Diane Sarkies - NWRL Cherrybrook-SSI-5414 Attention: Director, Infrastructure Projects

My name is Robyn Waite and I live at 18 Dalkeith Road Cherrybrook. I am writing to lodge my objection to this current proposal for the revised plans of Cherrybrook station in Robert Road.

Figure 6.12 Cherrybrook Station - Indicative vehicle and pedestrian movements

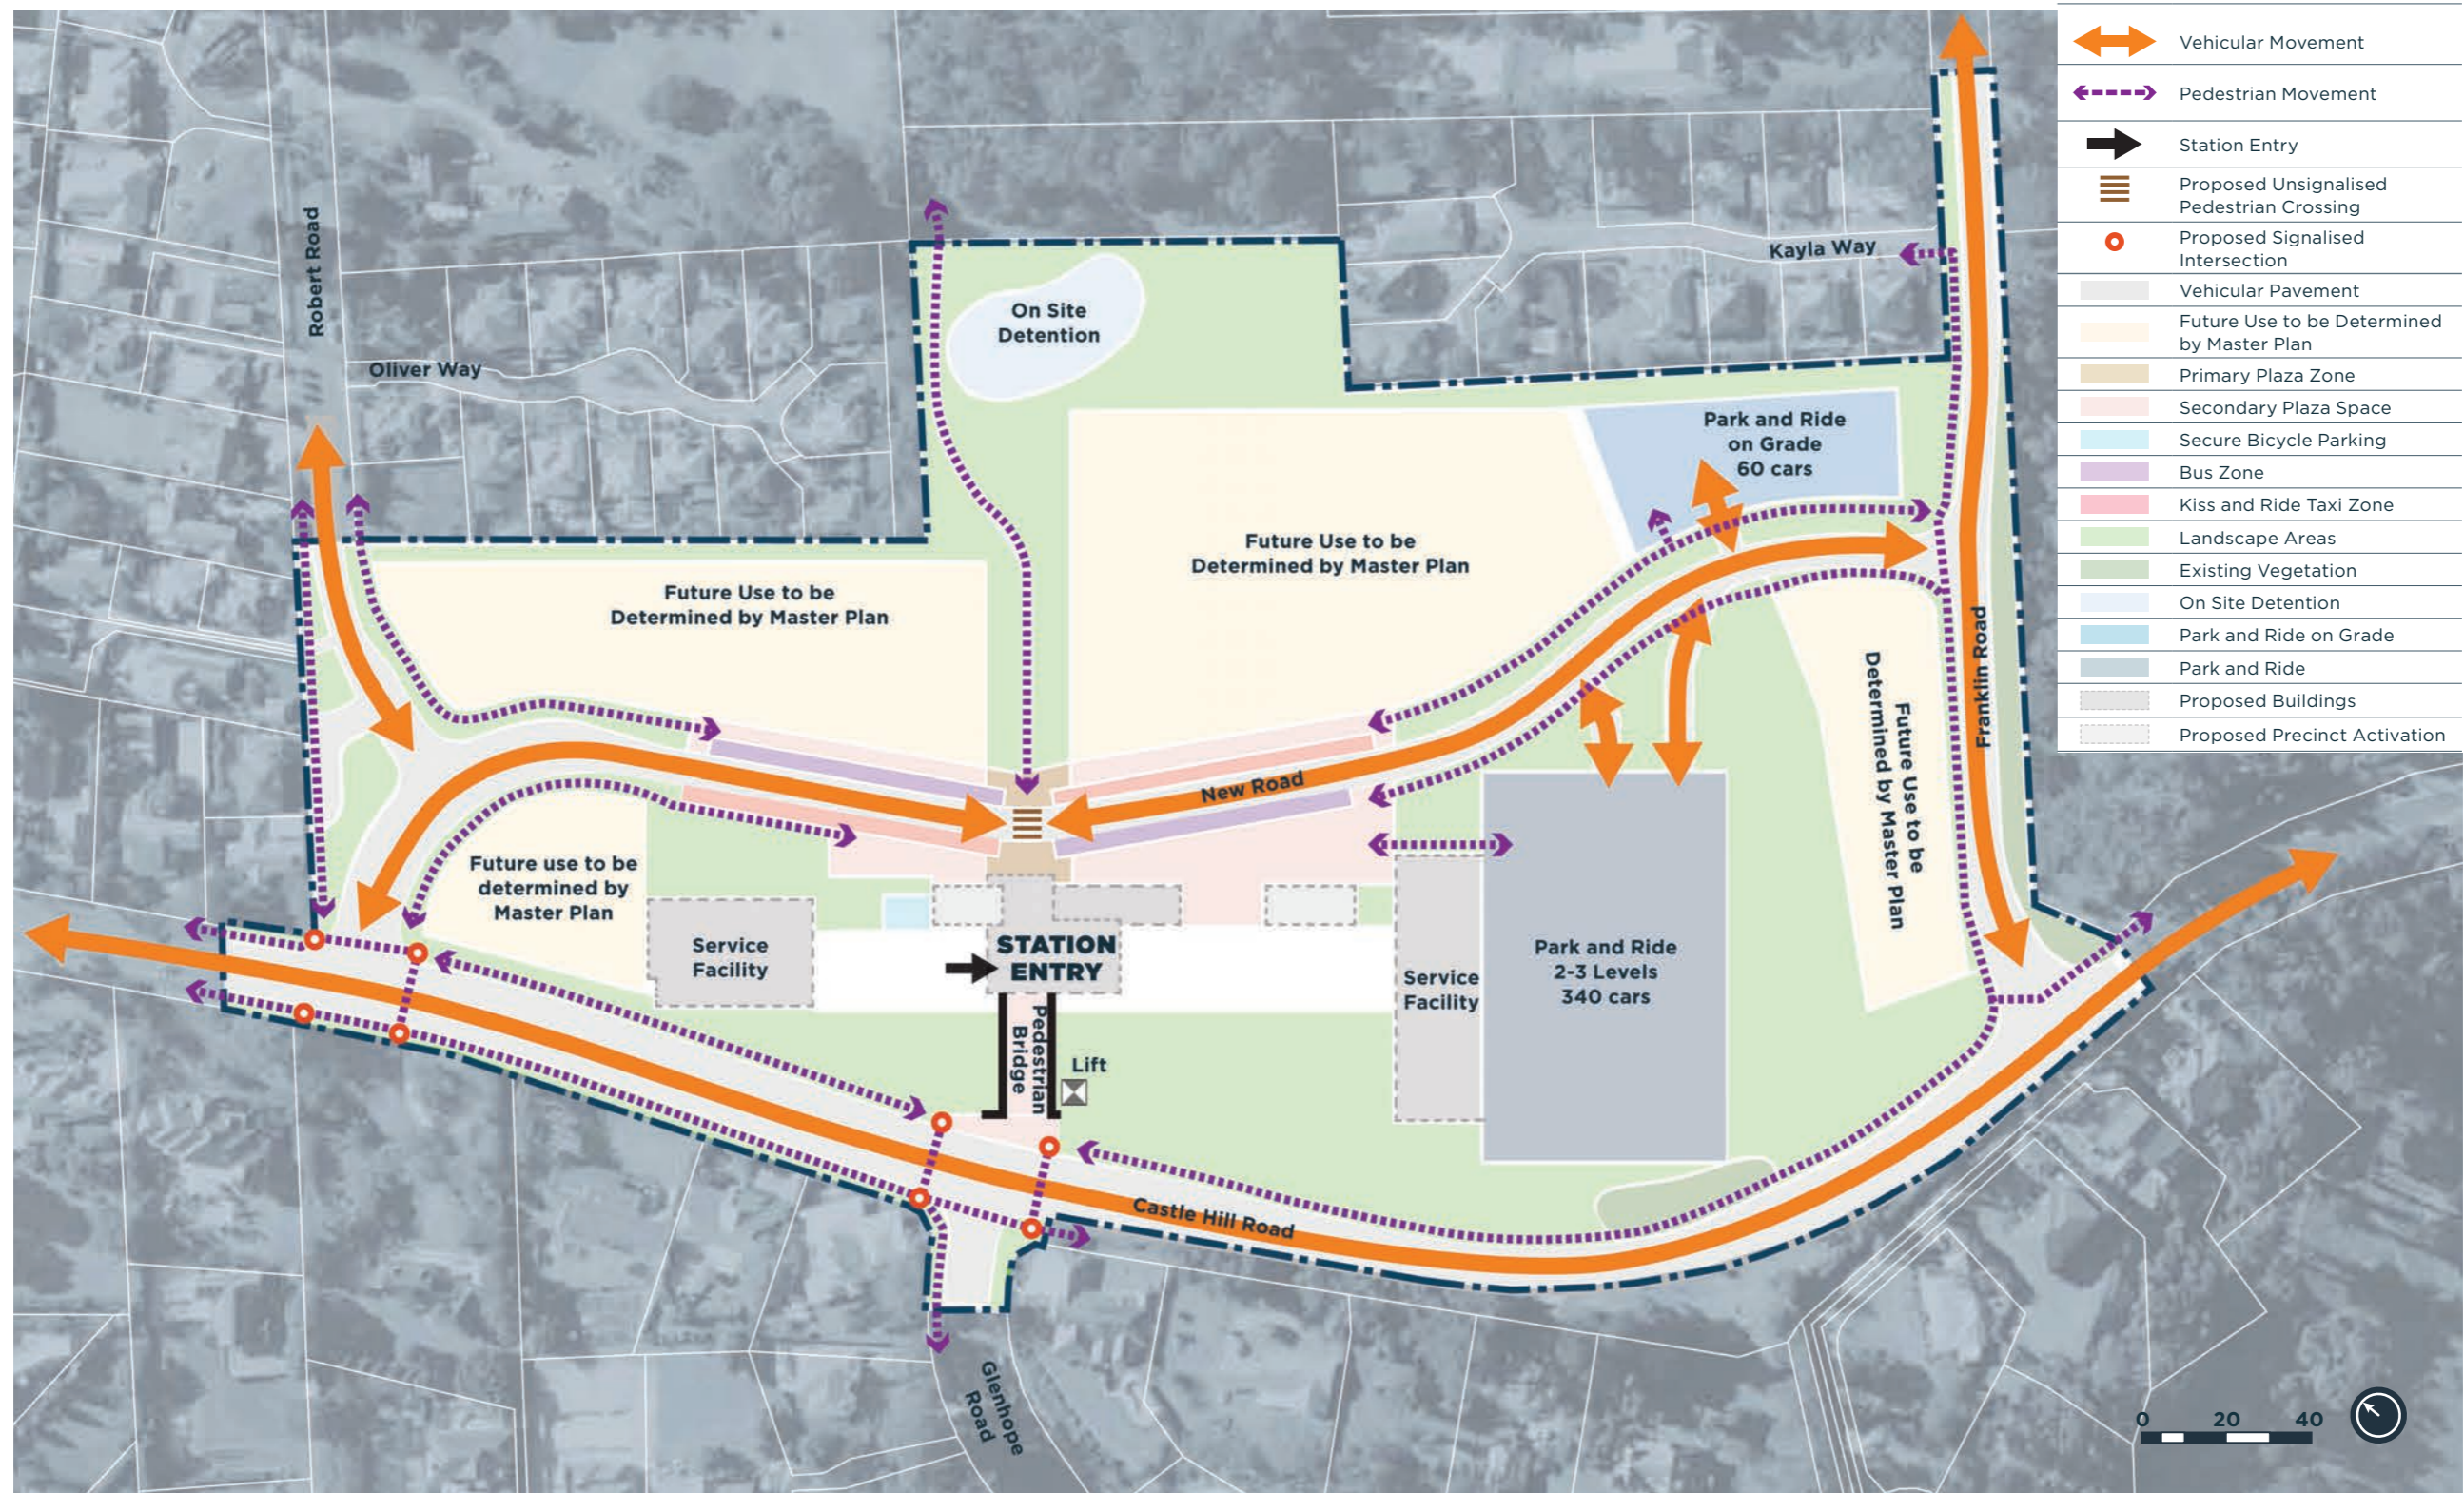
Dalkeith Road runs off Robert Road as do several surrounding streets for some 200-300 residences. The ONLY entry and exit to our streets is Robert Road. I am concerned that should an accident occur, our only entry/exit road would be cut off denying us access. How would emergency vehicles access a residence if the road was blocked or congested.

I am also concerned that given the 1st plan showed 960 car parking spaces and this one only 400, where do the other vehicles expected to use the station park? Robert Road is narrow and if made No Parking, the vehicles would overflow onto our surrounding streets. The curve at the bottom of Dalkeith Road is already marked with double lines and yet cars often ignore that and park making the road increasingly dangerous. I feel this now plan would only add to the potential for serious accidents.
